Re: Certification Submittal for Final Building Certificate of Occupancy for

RV-USA, [K-21 / D4] 11117 Skyline Dr. NE

Architect's Stamp Dated 11/22/06

SITE PLAN

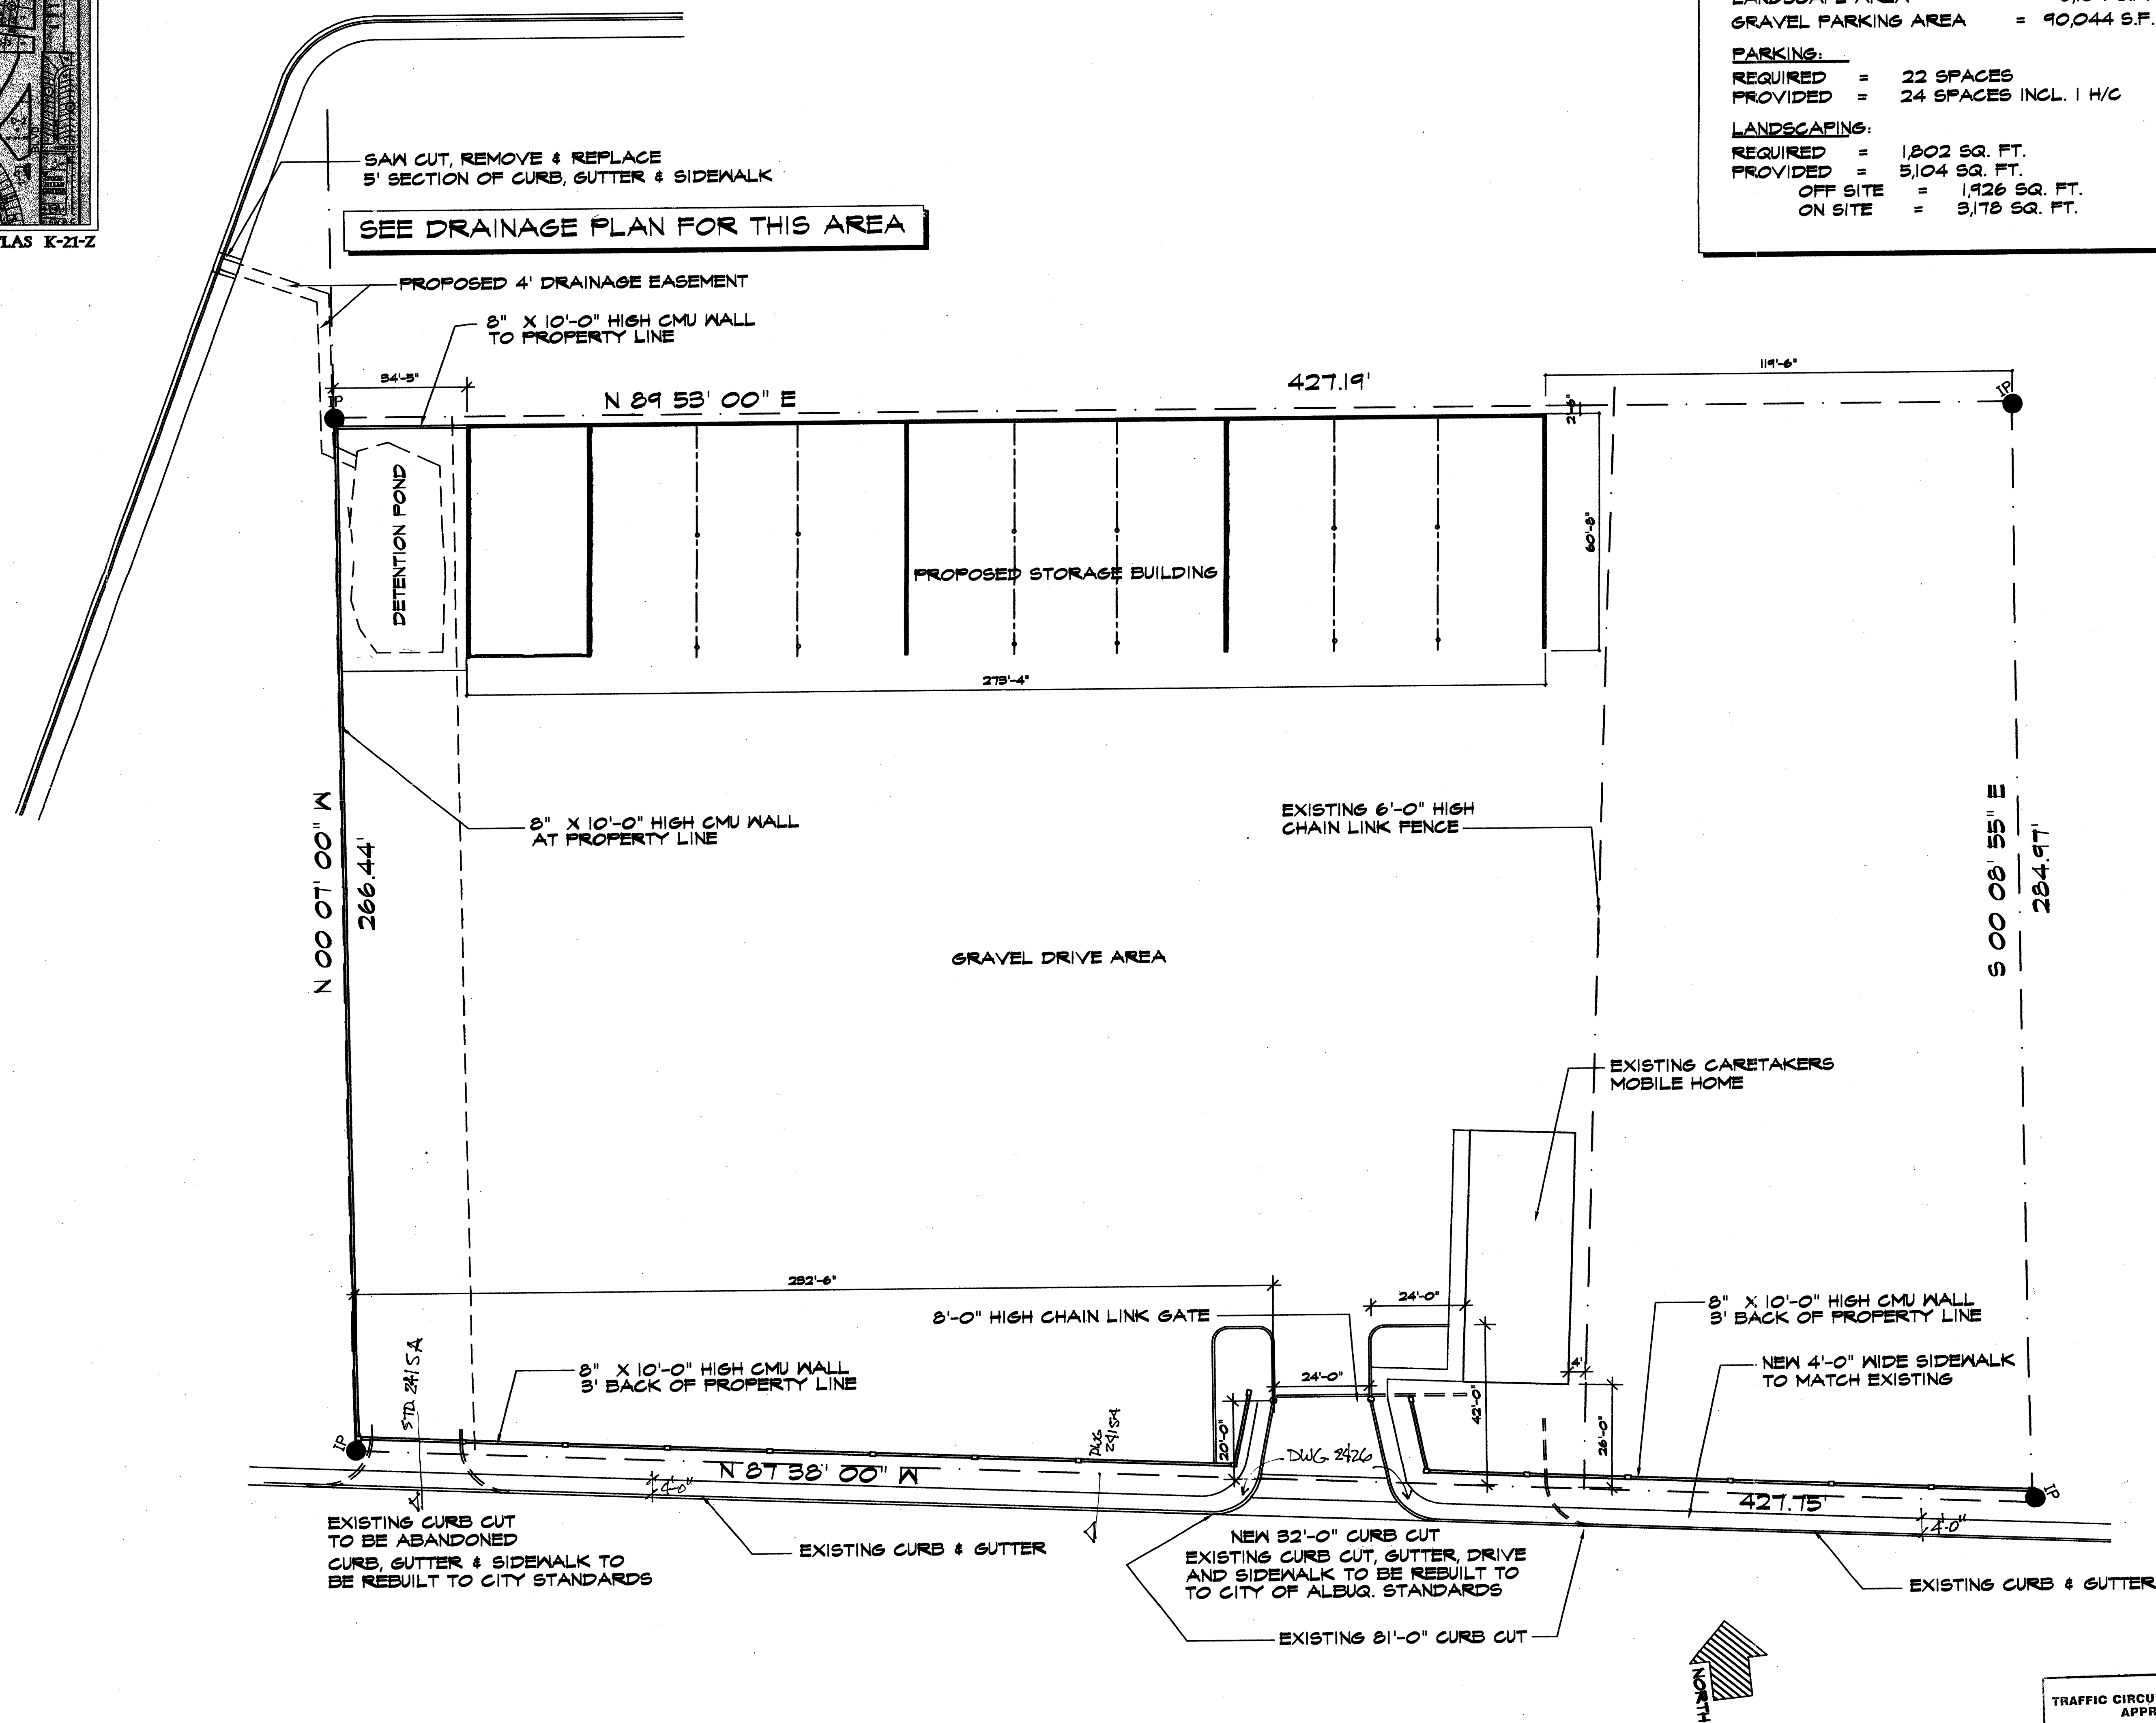
No permit was issued for the entrance work and so no inspection for entrance was accomplished. You'll need to pull permit for work within City of Albuquerque right of way and have an inspection for concrete work on entrance and wheel

chair ramps.
